From: Thomas Callaway
Sent: 18 May 2015 11:00
To: Planning.Responses
Subject: RE: Planning Consultation on: FP/55/15/PL

APPLICATION FP/55/15/PL

Site Address: Site 6 Phases 4 & 5 Land North of Felpham Felpham PO22 8FX

Description of Works: Erection of 38 No. residential dwellings with associated access, parking, landscaping & works (amended proposals for site already approved for residential development).

REV. No.	DATE	DESCRIPTION	INITIALS
Client			
Project	Phase 4 & 5 Replan Pelham, Bognor Regis		
Title	Drainage Layout		
Scale	1:250		
Drawing No.	5151:01		
Date	March '15		
Drawn	H.S.

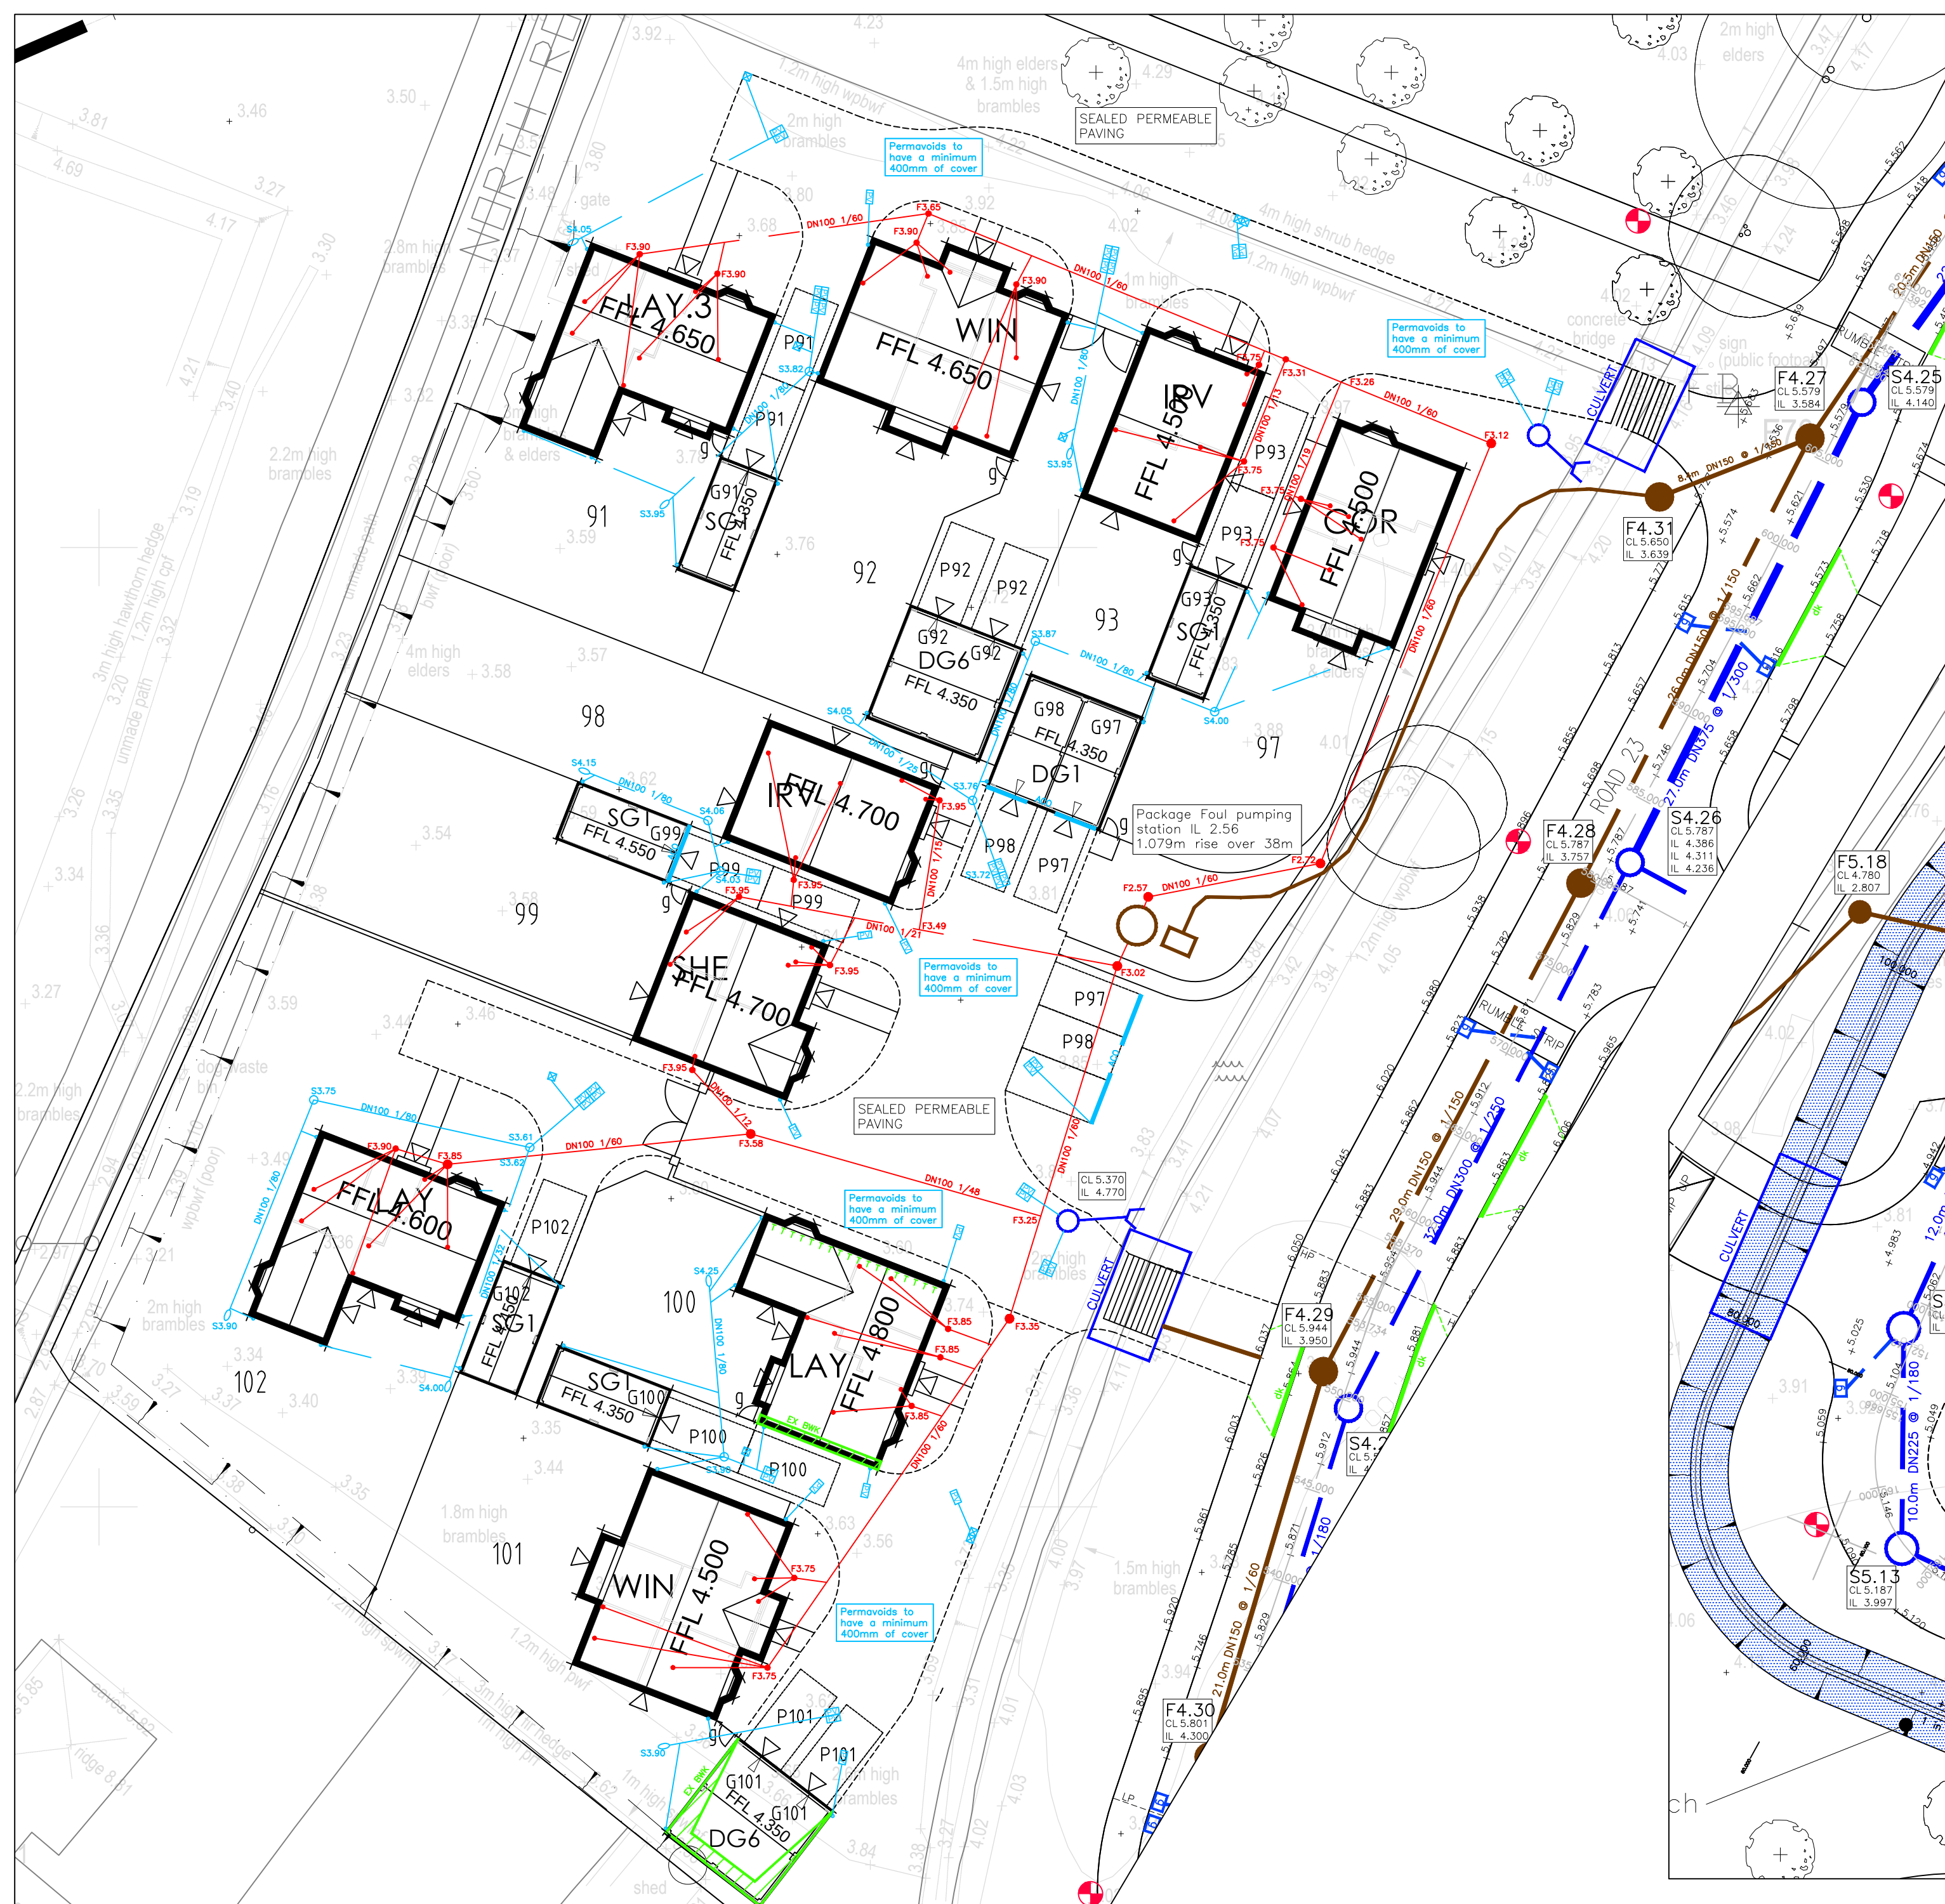
Surface water to be drained to the previously agreed system draining the wider development site.

The EA should be consulted to confirm that all proposals close to the IDB ditches are suitable, and all works in the watercourses (culverts etc) have proper consent prior to construction.
